CBD & South-East Light Rail Project - Modification 1 SSI 6042 (MOD 1)

Modification to CBD and South East Light Rail Project

Submitted to NSW Department of Planning and Environment
On Behalf of University of NSW

December 2014 ■ 13533

Figure 7-20: UNSW High Street Precinct Access Plan

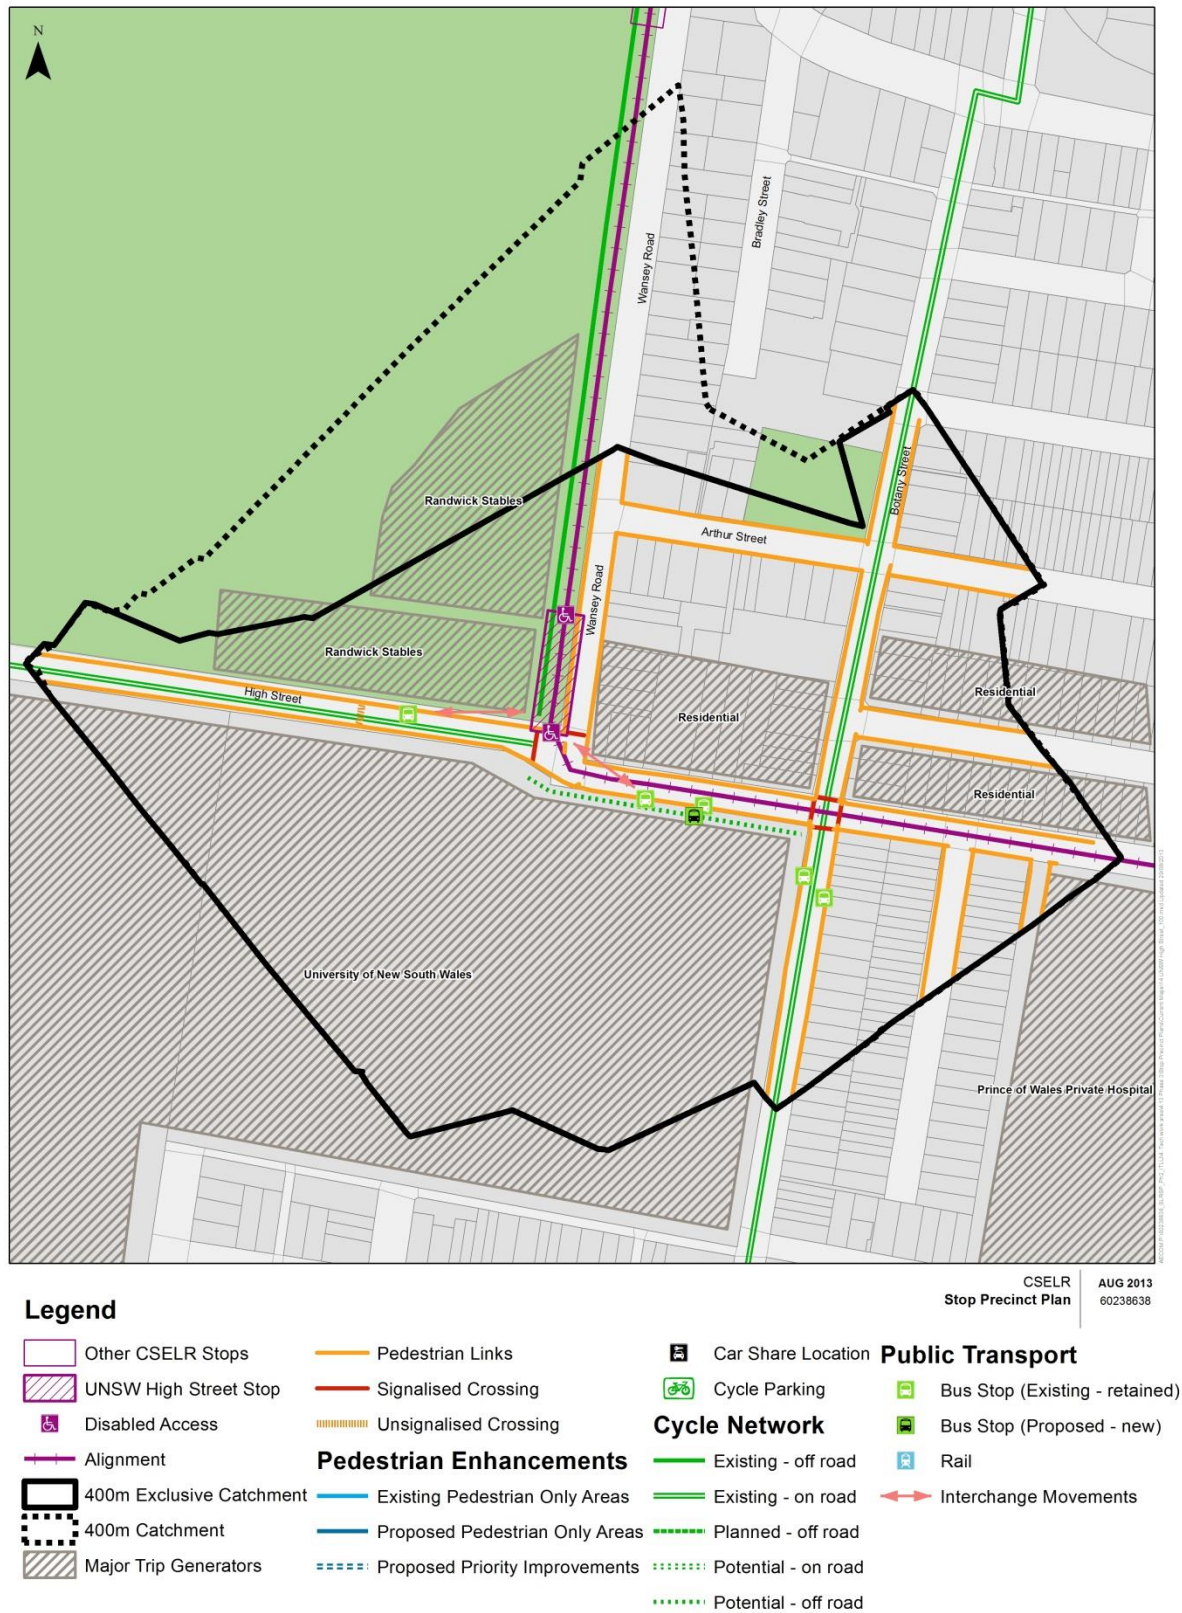
The increase in length of the platforms, as well as the increase in length of the LRV, has the potential to significantly change the layout and operation of the UNSW stops, in particular the High Street stop.

No details are provided regarding the proposed 67m long LRV such as door locations and swept paths. In particular, swept path changes at the intersection of High Street and Wansey Road may impact on the surrounding properties.

UNSW believes there is a real need to increase platform widths not just lengths to meet industry standard guidelines and design standards.
